CITY OF ALBUQUERQUE

RE: **1105 Yale Blvd SE**
Grading Plan
Engineer's Stamp Date: 7/23/18
Hydrology File: L15D062

Based on the submittal received on 7/23/18, the Grading Plan cannot be approved until the following are corrected:

SECTION A-A

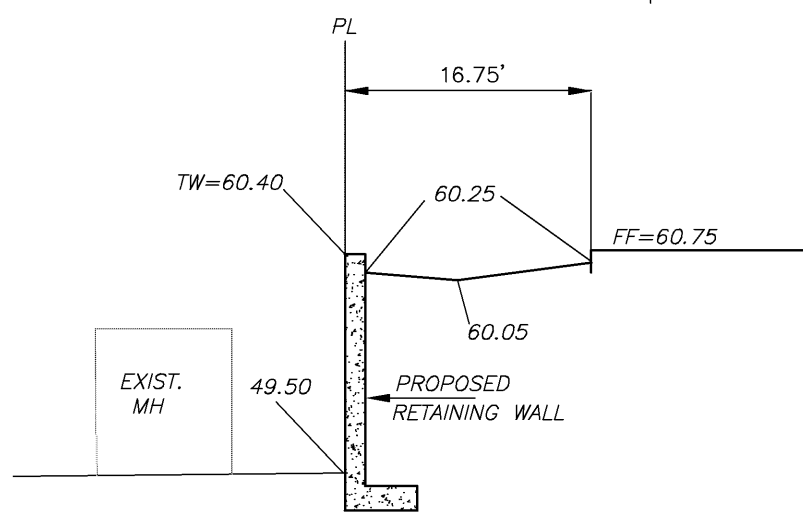
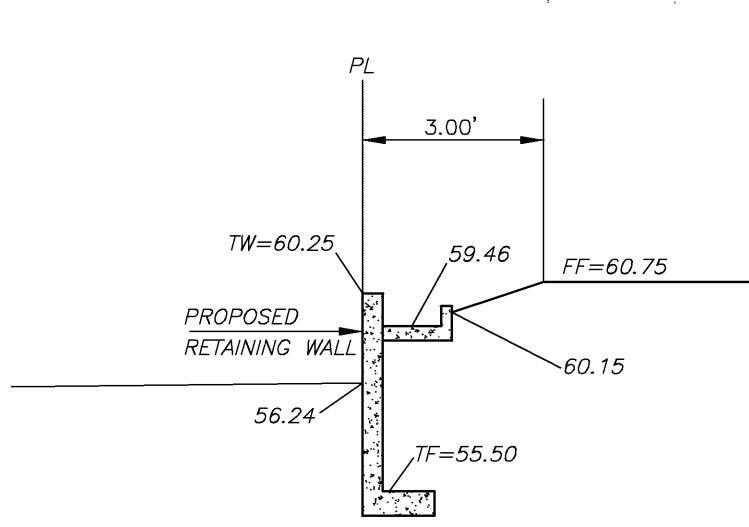
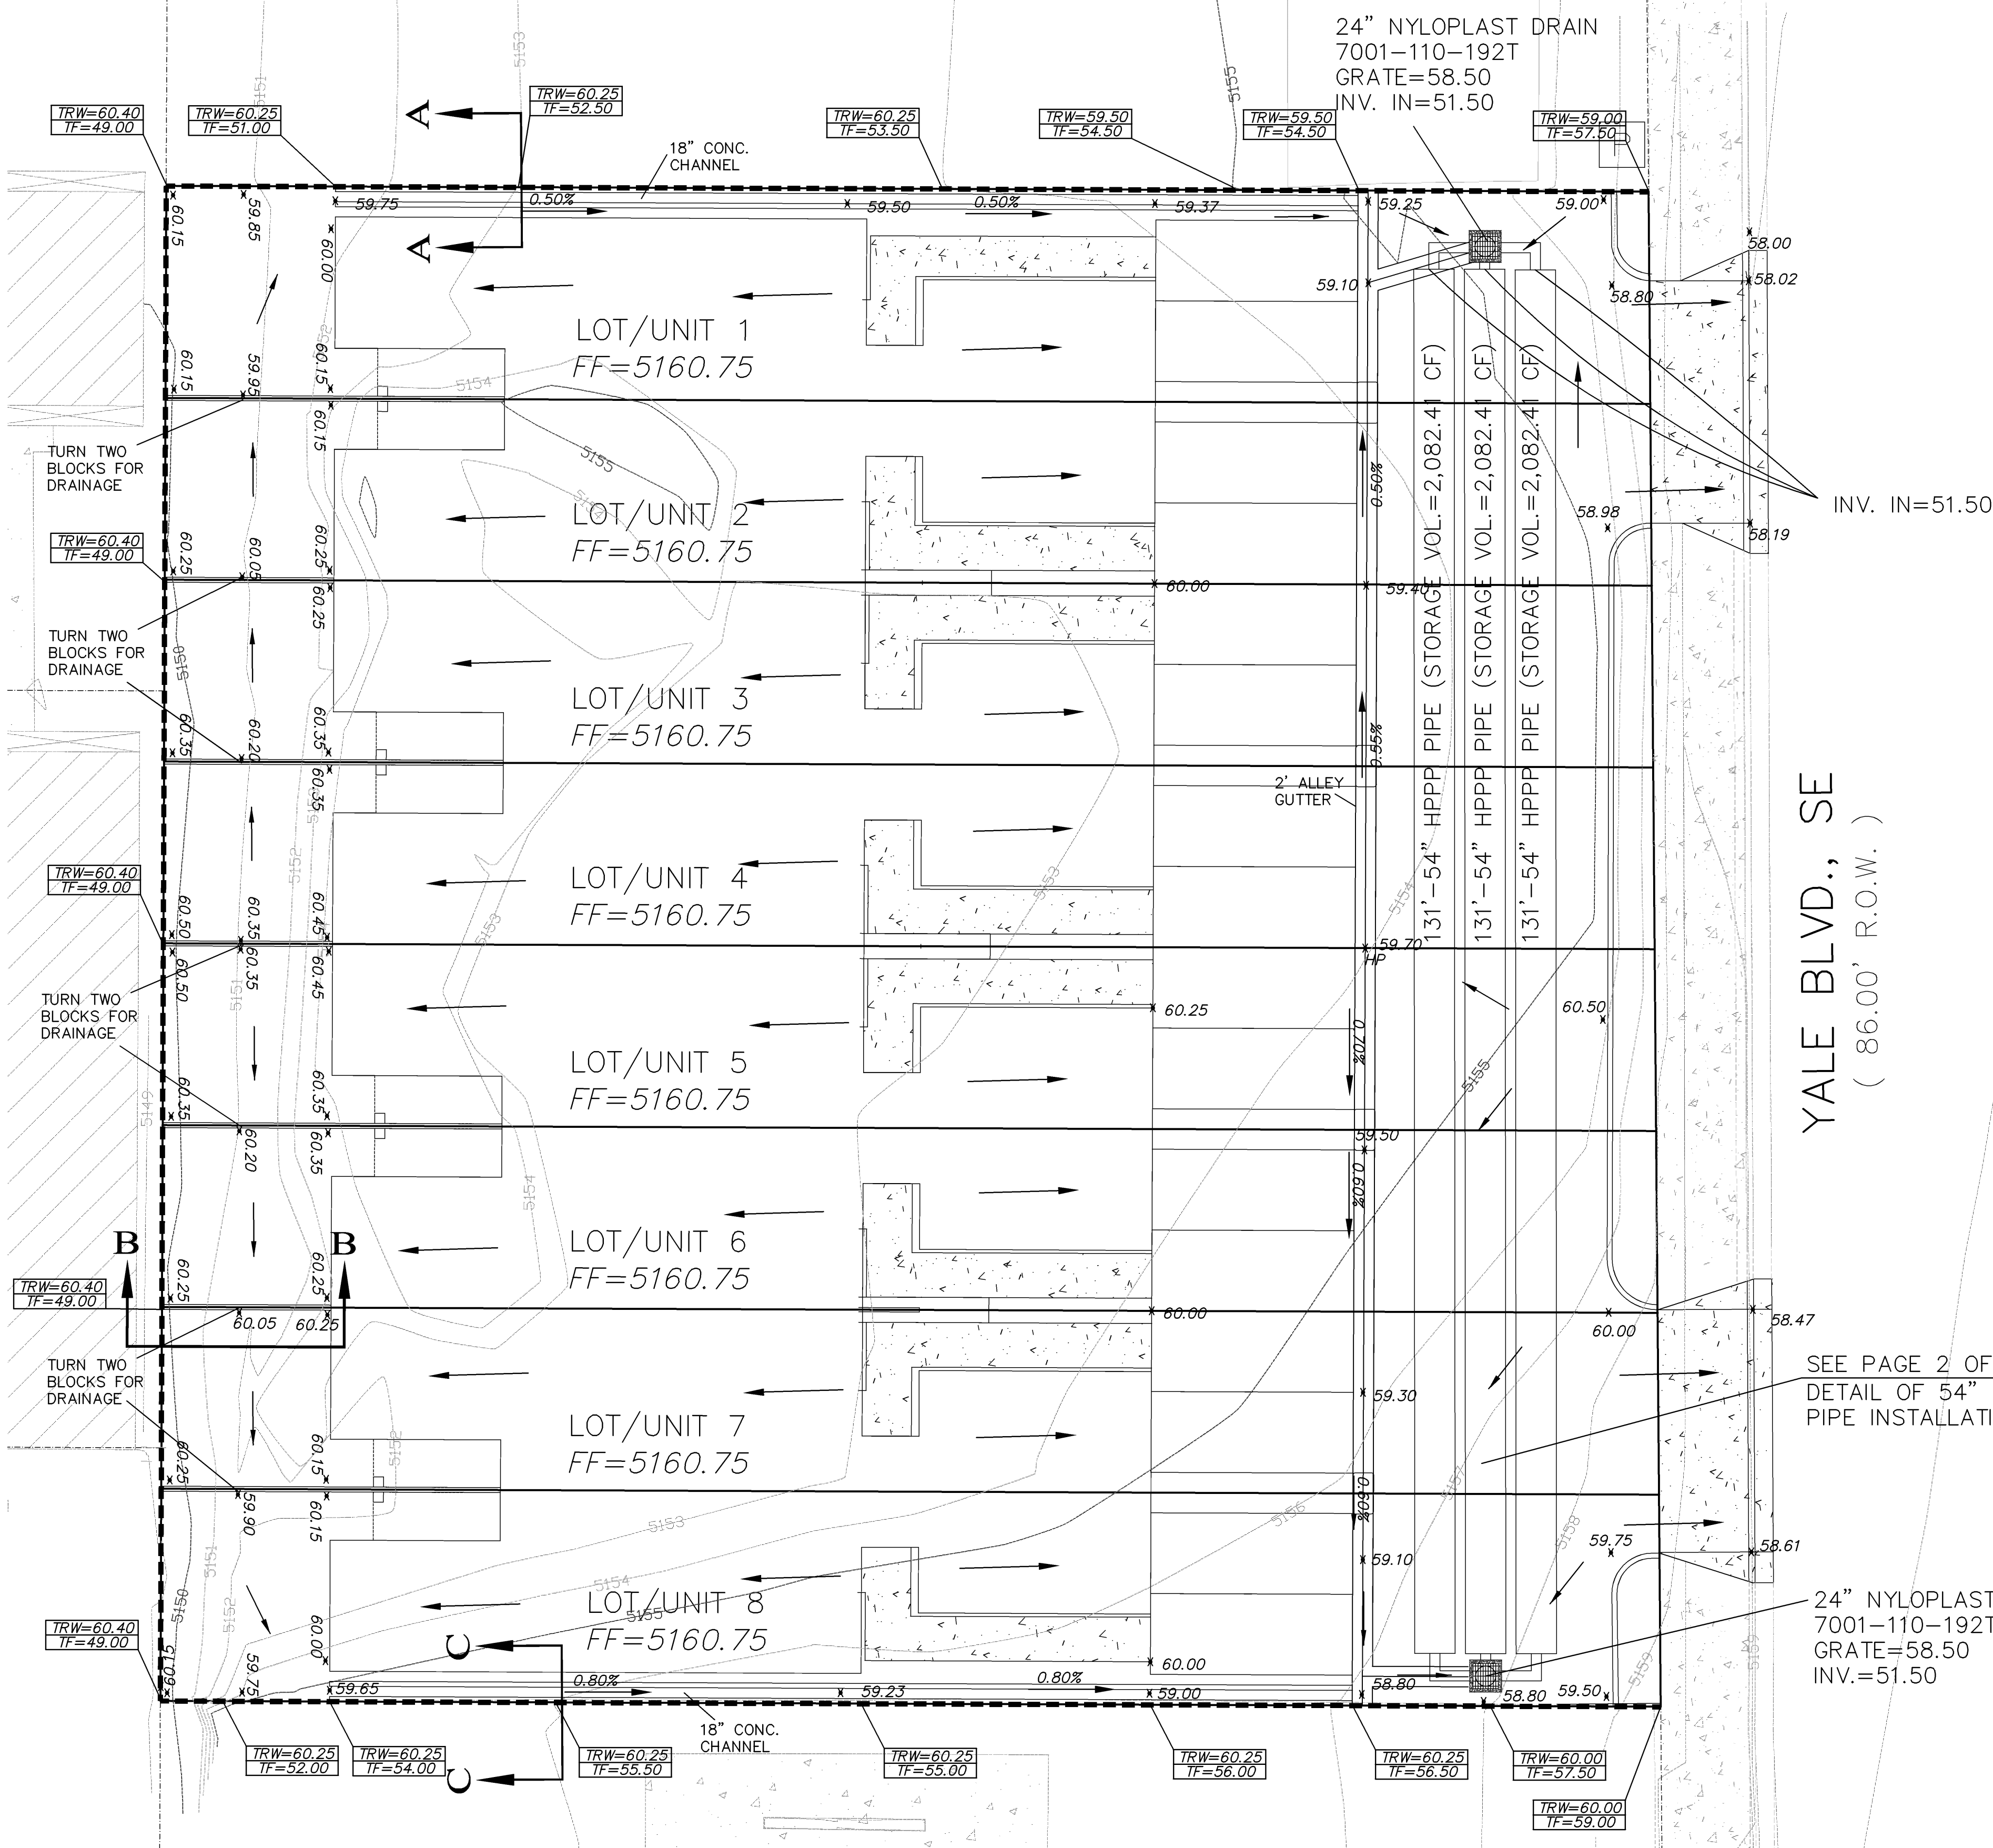
2. Provide wall sections for all cases around this property. Show property lines, walls, footers, horizontal and vertical dimensions, and existing and proposed elevations on both sides of the walls. In accordance with DPM Ch.22, section 5 part B, grading and wall construction near the property line may not endanger adjacent property or constrain its use.

3. Provide structural details for the wall on the west property line. This wall will need to be designed for saturated conditions due to its proximity to the pond. Also show the maximum water surface elevation and provide 2.0' (minimum) freeboard around the pond.

**1105 YALE BLVD., SE
GRADING PLAN**

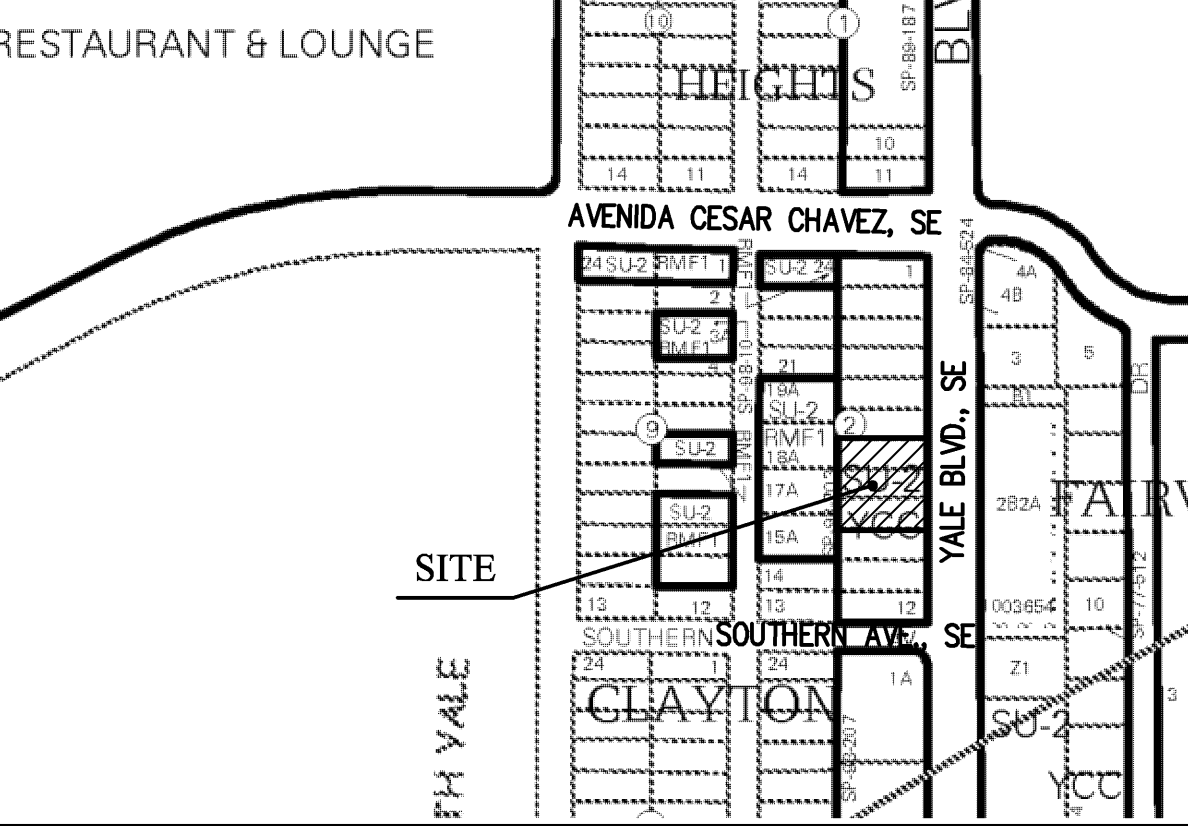
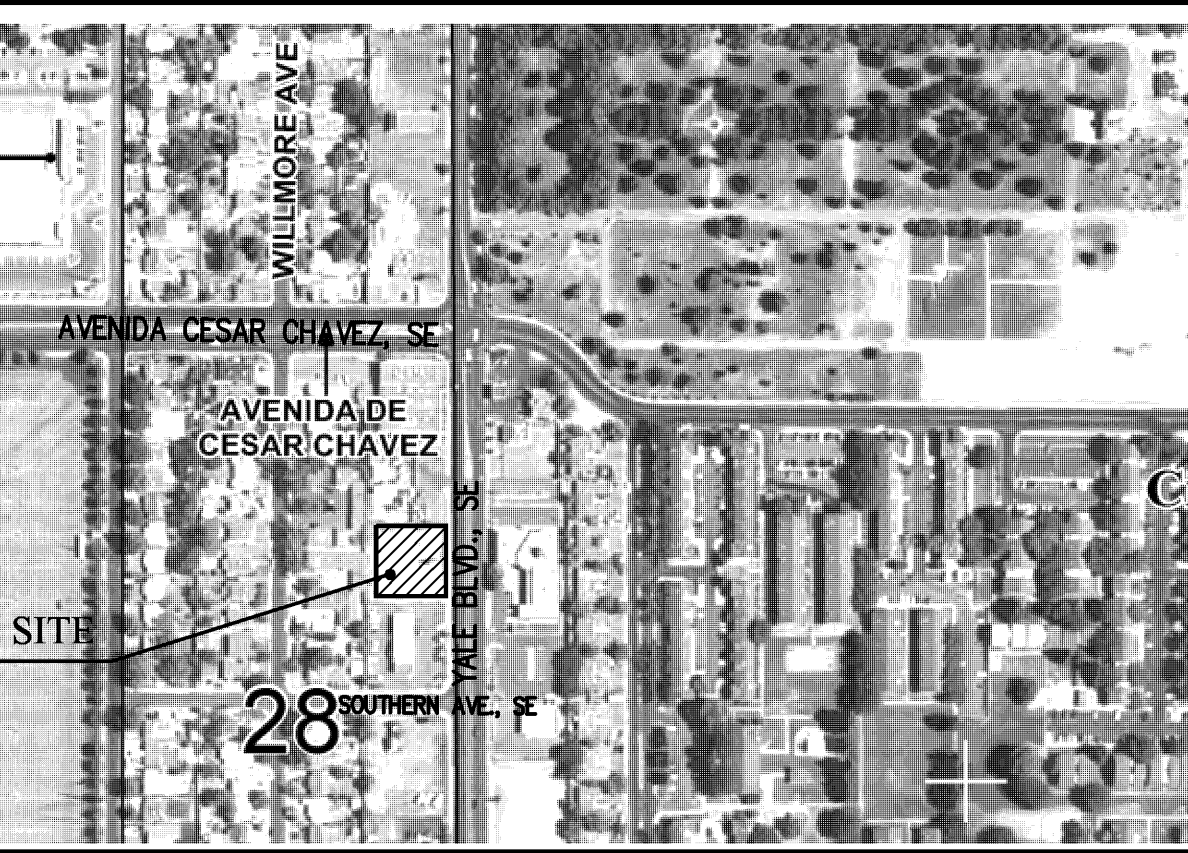
1. The site must demonstrate adequate downstream capacity per § 14-5-2-12(G) of the Albuquerque Code of Ordinances. This property has never drained to Yale and its runoff was not anticipated in sizing infrastructure on Yale. This property will likely have to retain all runoff on-site (100-yr, 10 volume) or obtain a drainage easement from a neighbor to drain south or east.

4. Consider the constructability of a channel on a 0.2% slope. This will need to be surveyed as part of the Engineer's Certification and ripped out and replaced if not able to drain per plan.

5. The concrete channels need to provide 1.0' (minimum) of freeboard and manning's n for poured concrete is 0.13. The channel is sized as an 18" wide channel, but called out in plan view as 12" wide.

9. Provide a subbasin delineation map and define the areas of impervious cover. First flush retention ponds must capture runoff from the impervious areas and the ponds must be sized for the areas draining to them. If unable to capture the first flush runoff, quantify the first flush bypass volume and state on plans. Payment of the Fee in Lieu (Amount = BypassVolume x \$8/cf) will then be required.
